Consultation response from Ecology

From: Charlotte Watkins <Charlotte.Watkins@Cherwell-DC.gov.uk>
Sent: Friday, November 17, 2023 2:19 PM
To: Rebekah Morgan <rebekah.morgan@cherwell-dc.gov.uk>
Subject: 22/01682/F: Land North of Manor Farm, Noke

22/01682/F: Land North of Manor Farm, Noke
Additional information

PROXIMITY ANALYSIS - THIRD PARTY PROJECTS AND RSPB RESERVES

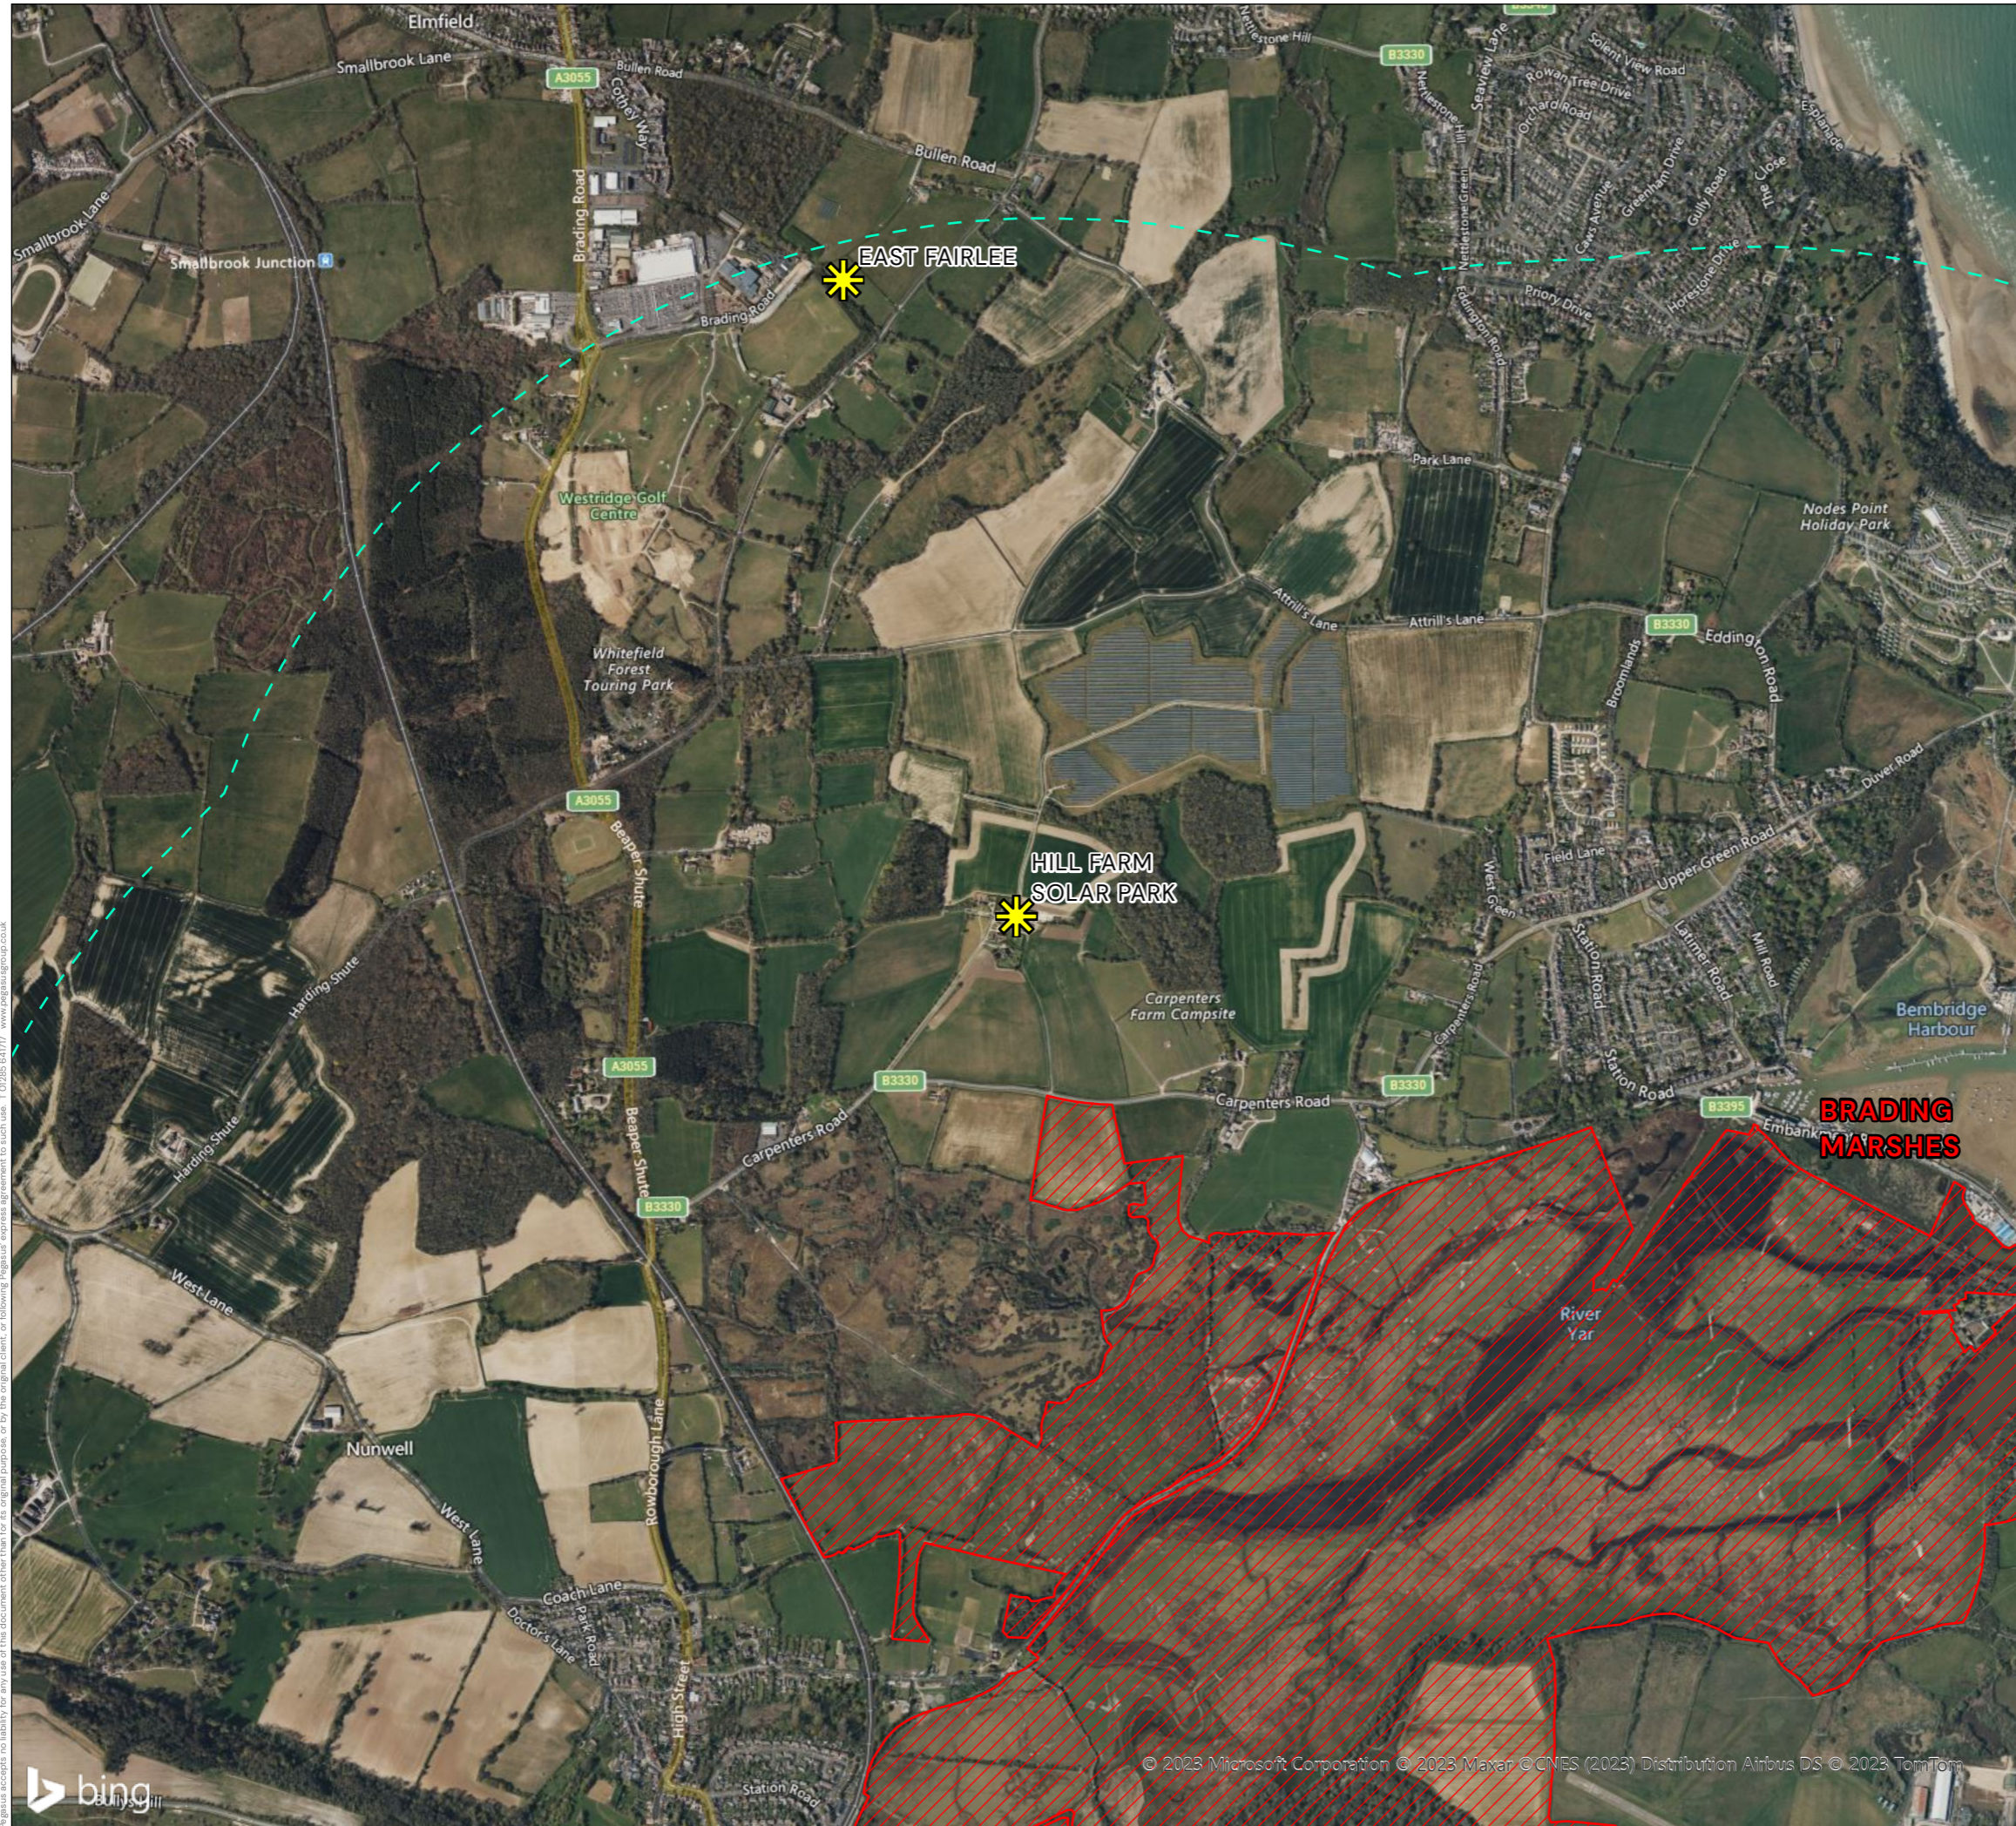
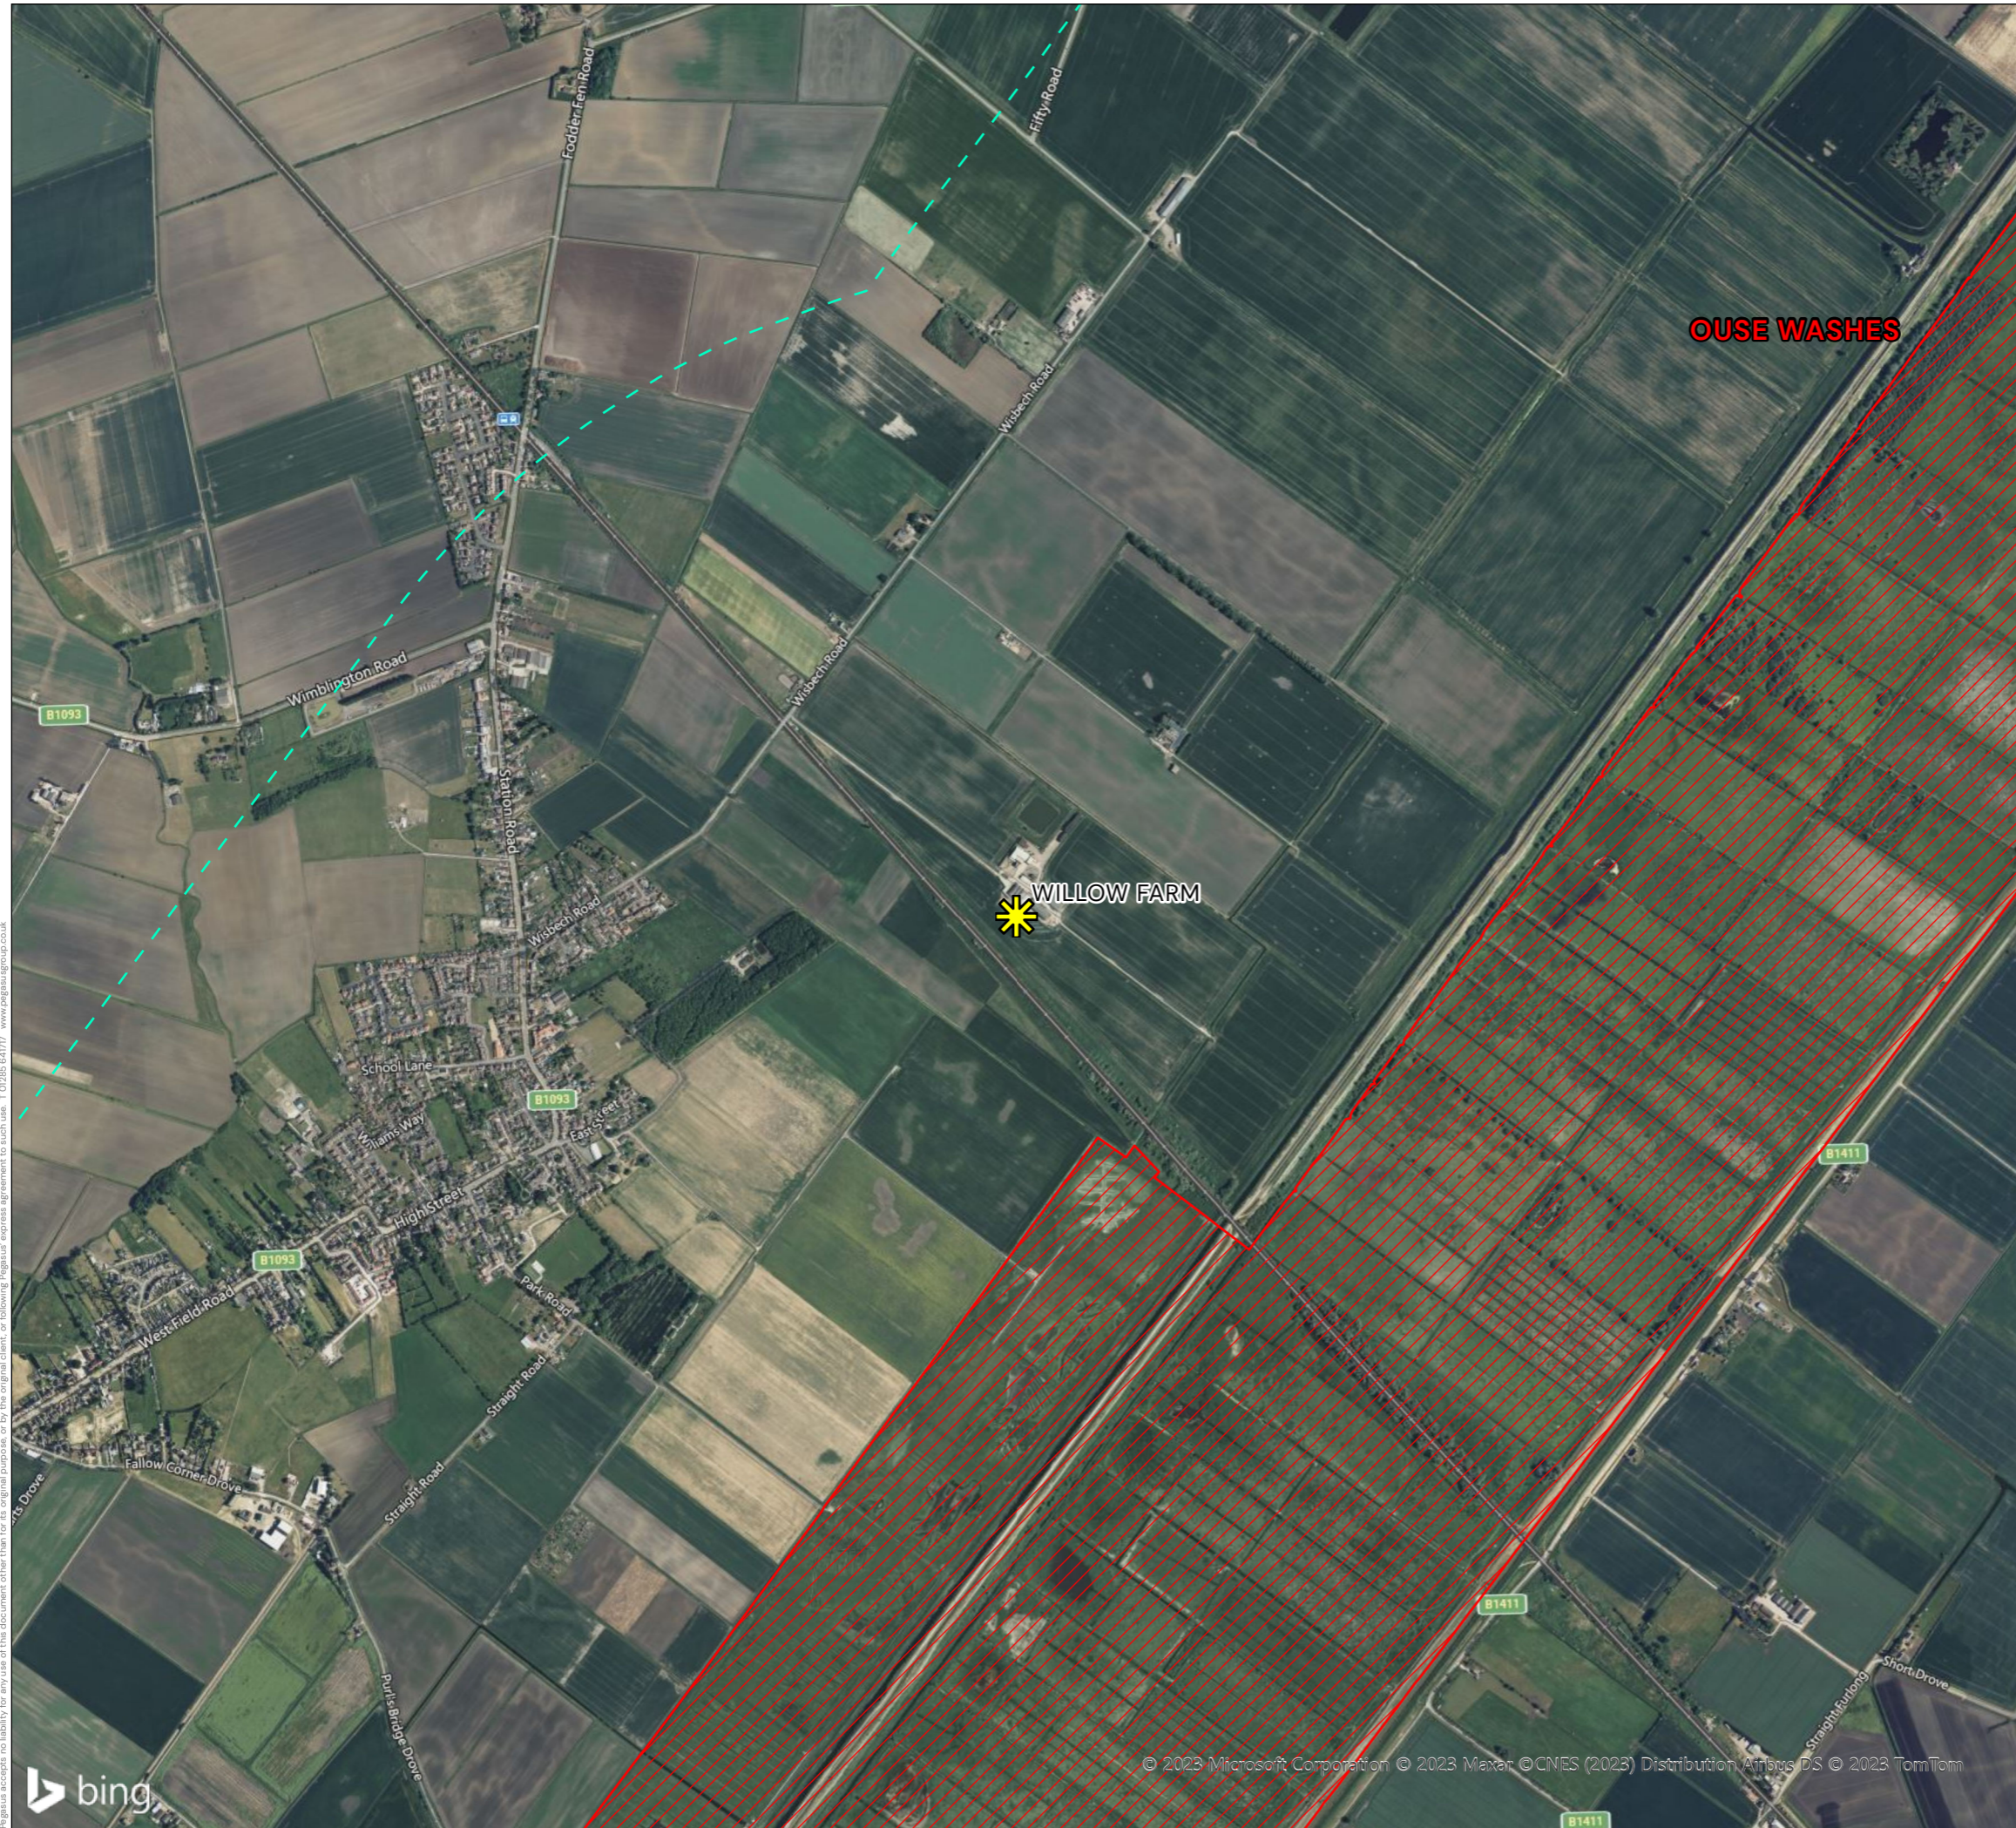
The applicants have submitted a helpful plan showing the proximity of some solar farms to RSPB reserves across England and I accept therefore that there are precedents for solar farms sited within close proximity of designated wetland areas. I note however that for at least one of the sites illustrated the RSPB themselves strongly objected to the siting because of its proximity to the reserve and because it prevented the future expansion of the reserve (Objection to Cleeve Hill Solar Park 2019, RSPB). I could find no monitoring information on the impact that any of these functioning solar farms may have had.
